Submissions Report No. 2  
New High School in Bungendore  
SSD-14394209

On behalf of  
NSW Department of Education  
November 2022

This Submissions Report has been prepared by Mecone Group Pty Limited on behalf of the NSW Department of Education to support the proposed new high school in Bungendore (SSD-14394209).

0m 5 10 15 20

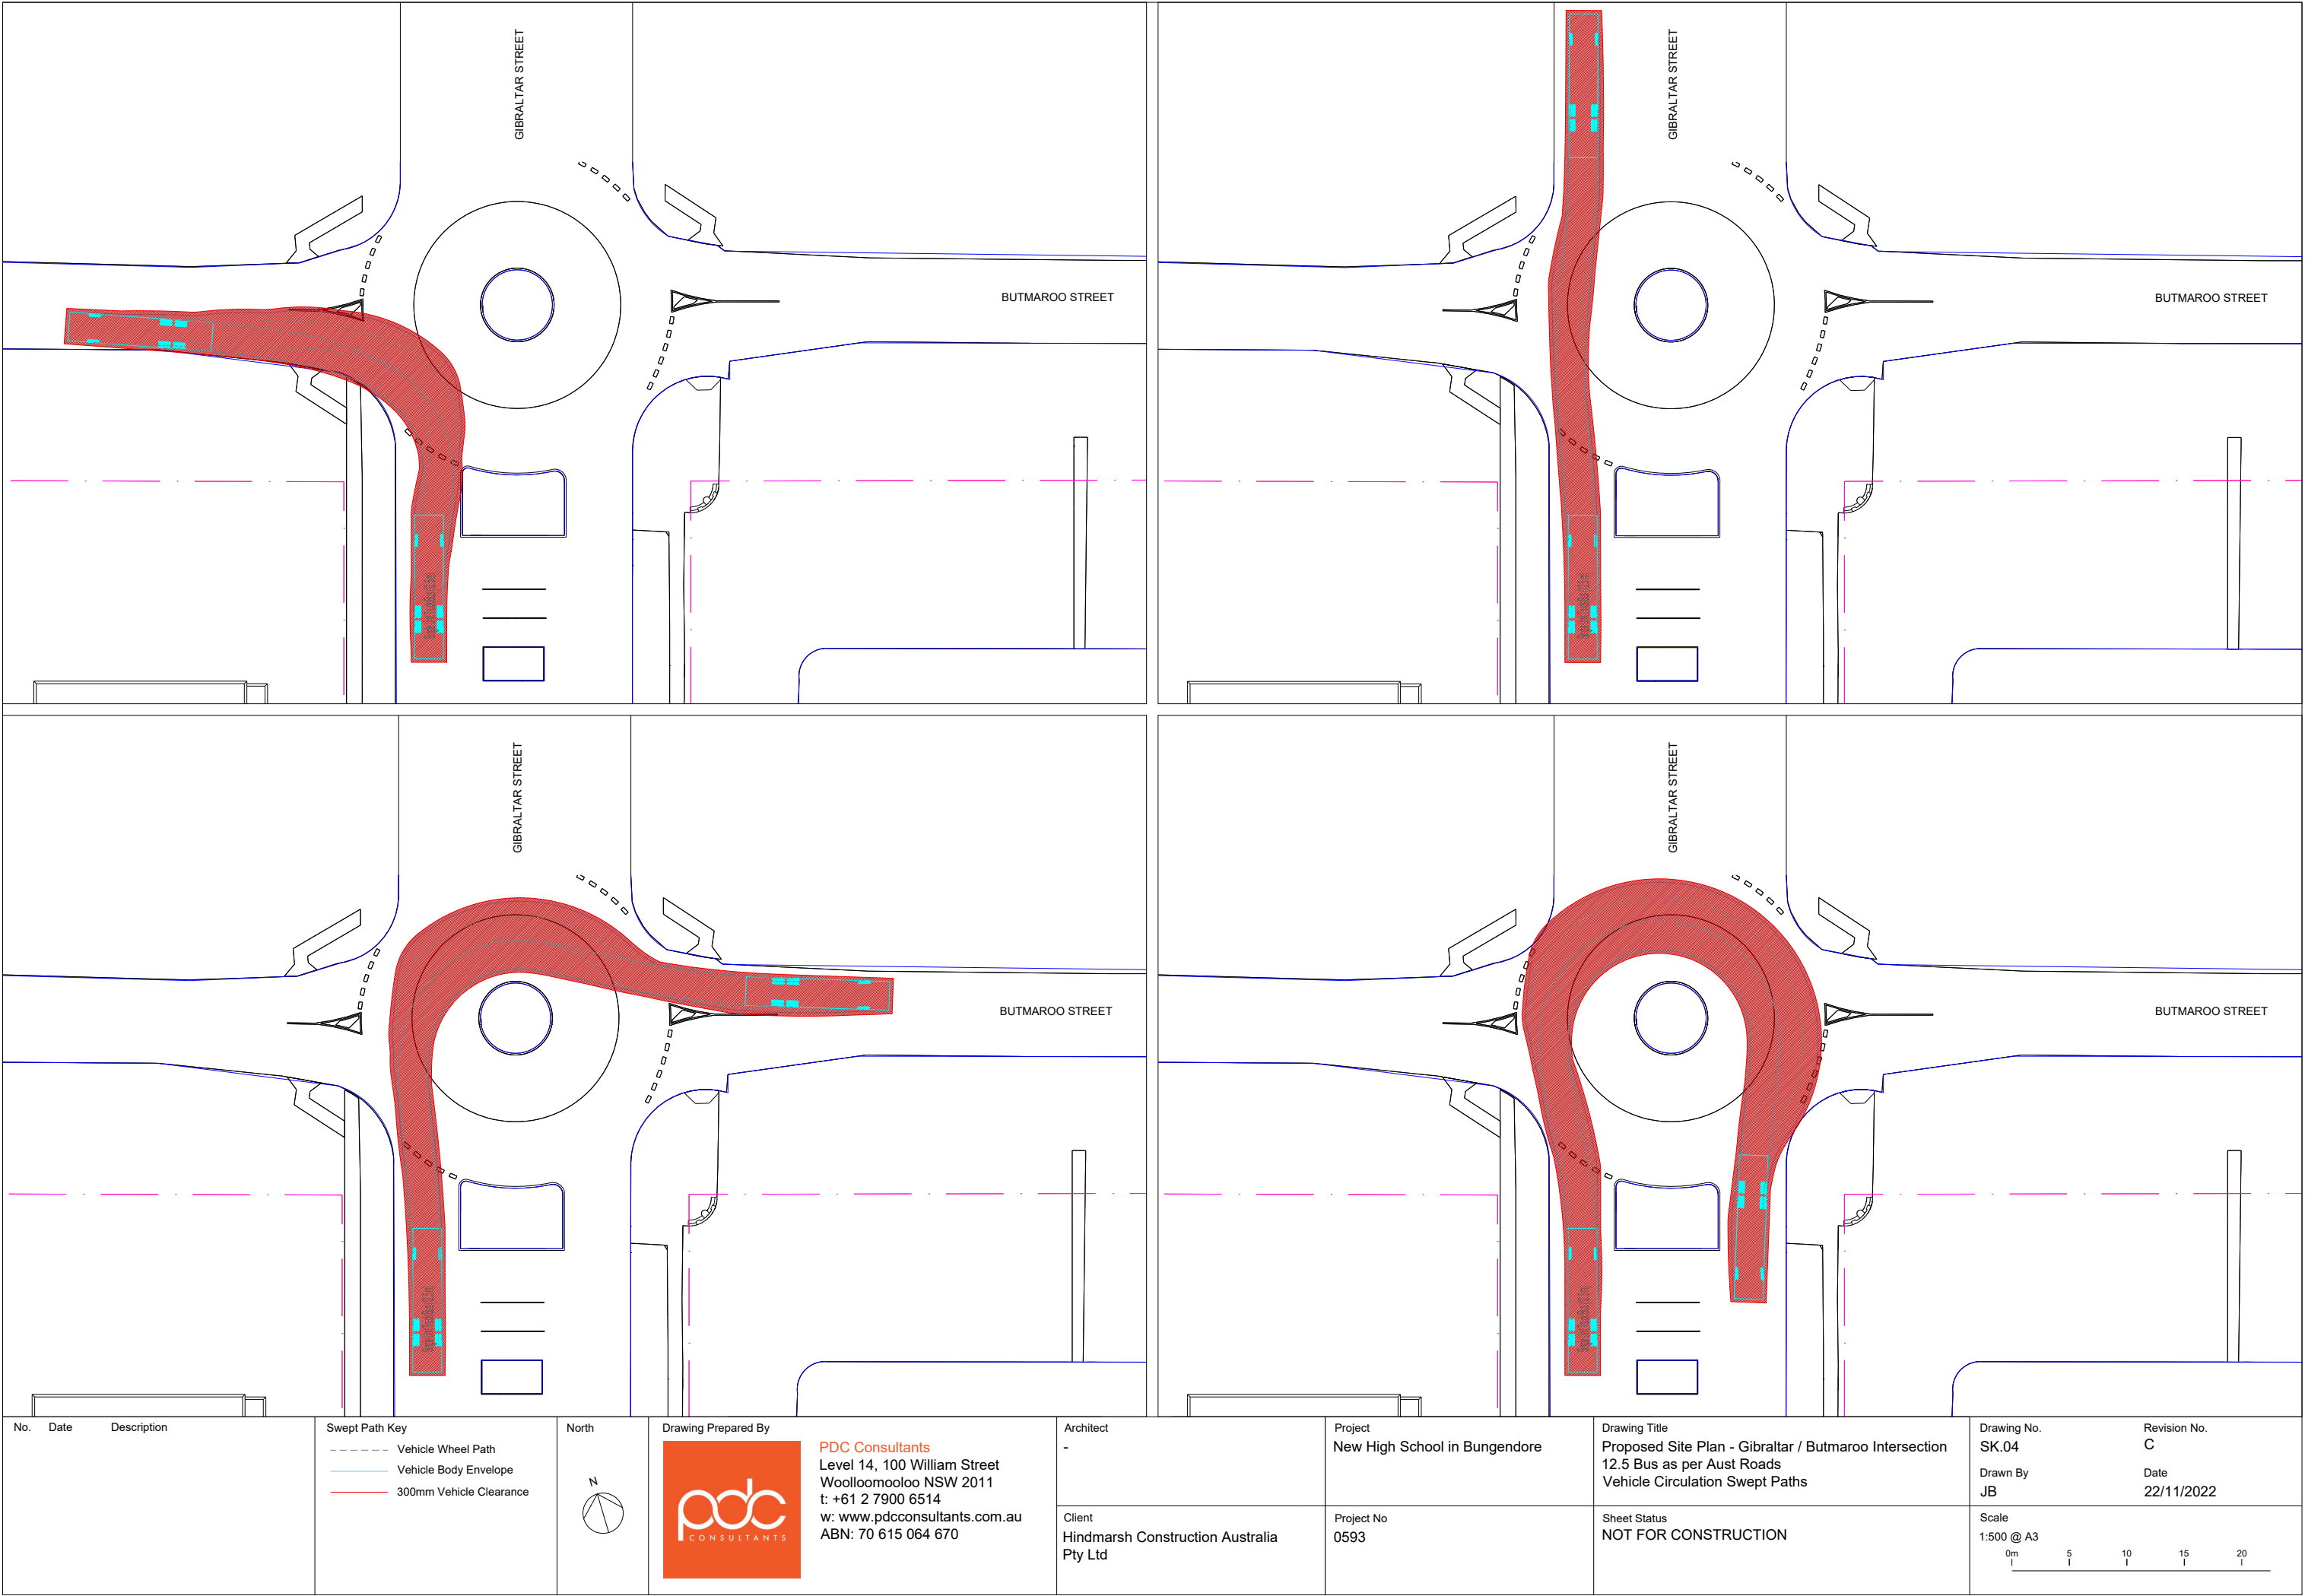
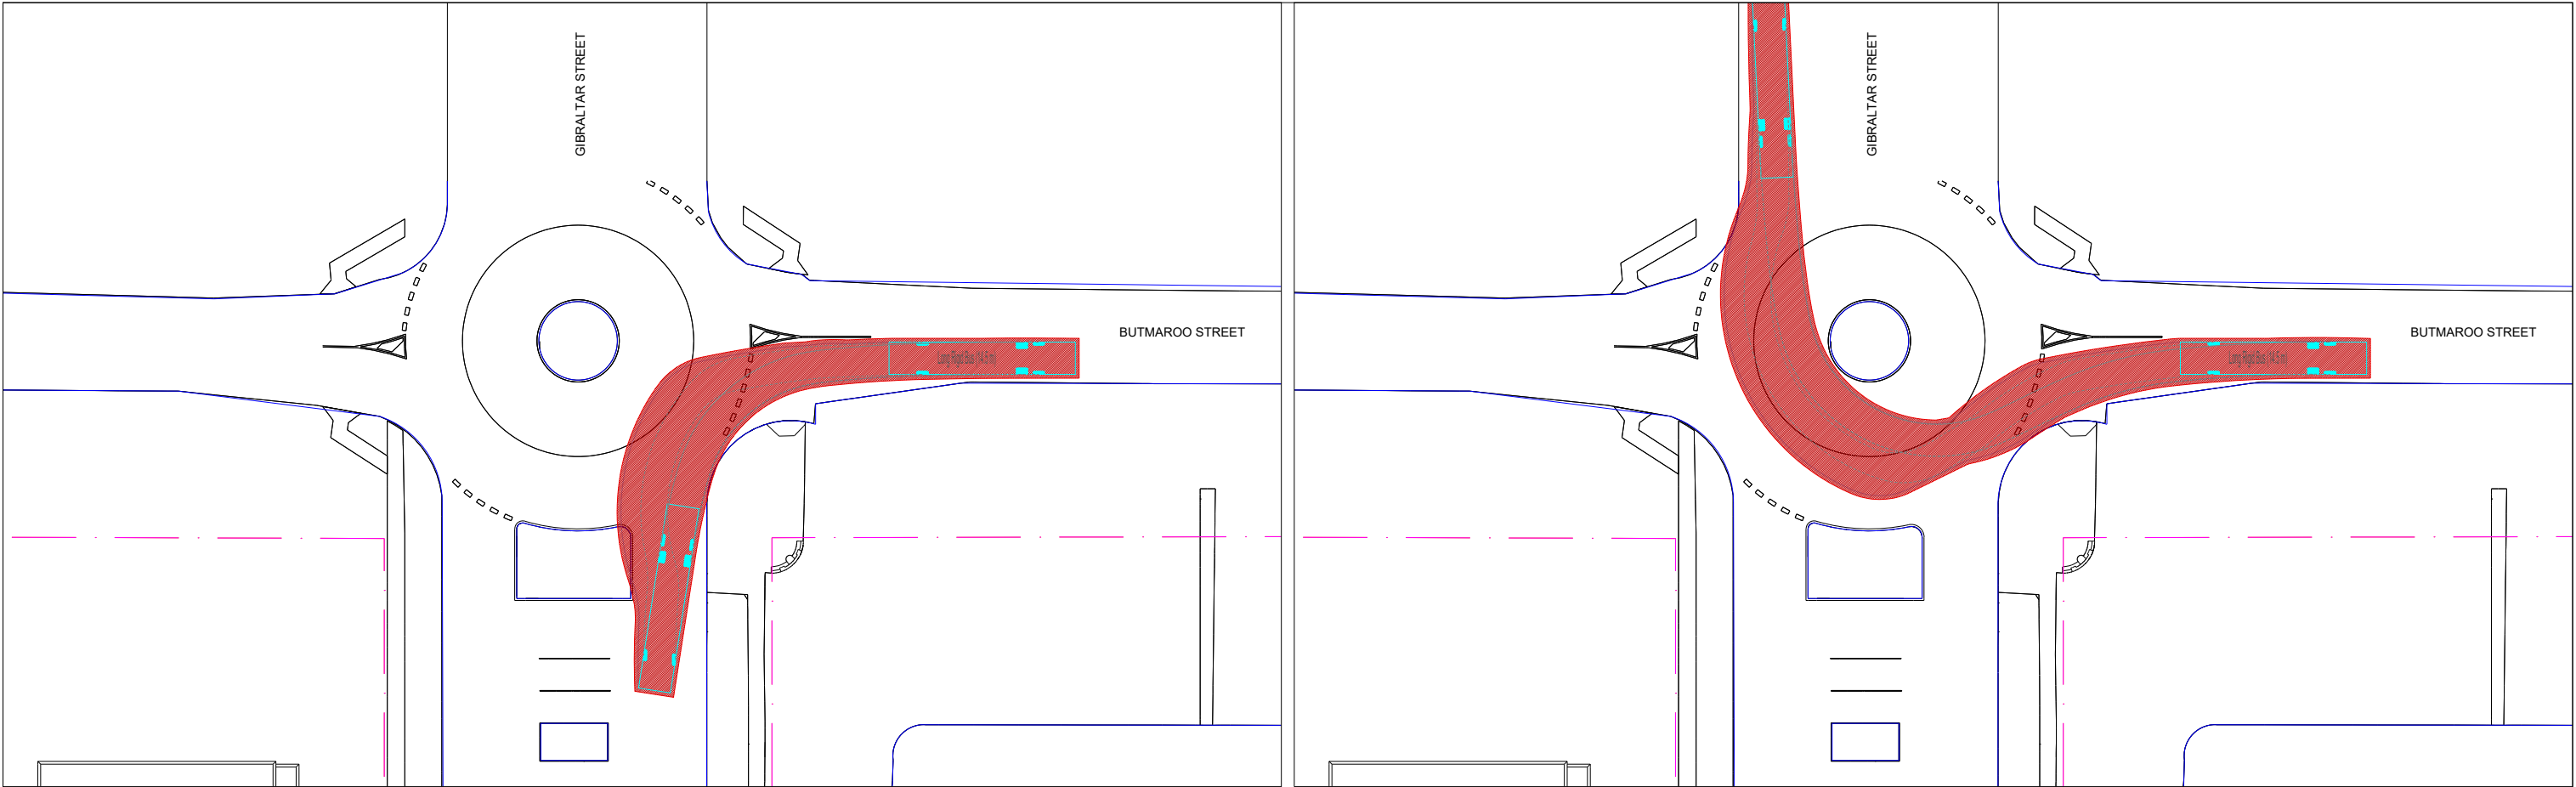
Council comment	Council recommendation	Response
by the frequent closure of Street due to flooding.		
<u>Roundabouts – manoeuvring:</u> Turning curves for a both 12 & 14 m buses need to be done at the Gibraltar/Majara Street and Gibraltar /Butmaroo roundabouts noting that this road is on our public transport route and adjacent to the train station. It isn't clear in the transport assessment addendum.	That the applicant provide engineered designs, noting any works to be carried out on verges adjacent to the proposed roundabouts on Gibraltar/Majara and Gibraltar/Butmaroo to facilitate turning movements for both 12 & 14 m buses, noting that these roads are on the public transport route and adjacent to the train station. It isn't clear in the transport assessment addendum. Note: During rail track works up to 3 full size coaches a day require to pull into the train station car park.	Kerb adjustments are required to facilitate the bus movements. The architectural, landscape and civil drawings have been updated accordingly ( <b>Appendix 3, 4 and 5</b> ). Swept paths are provided at <b>Appendix 9</b> .
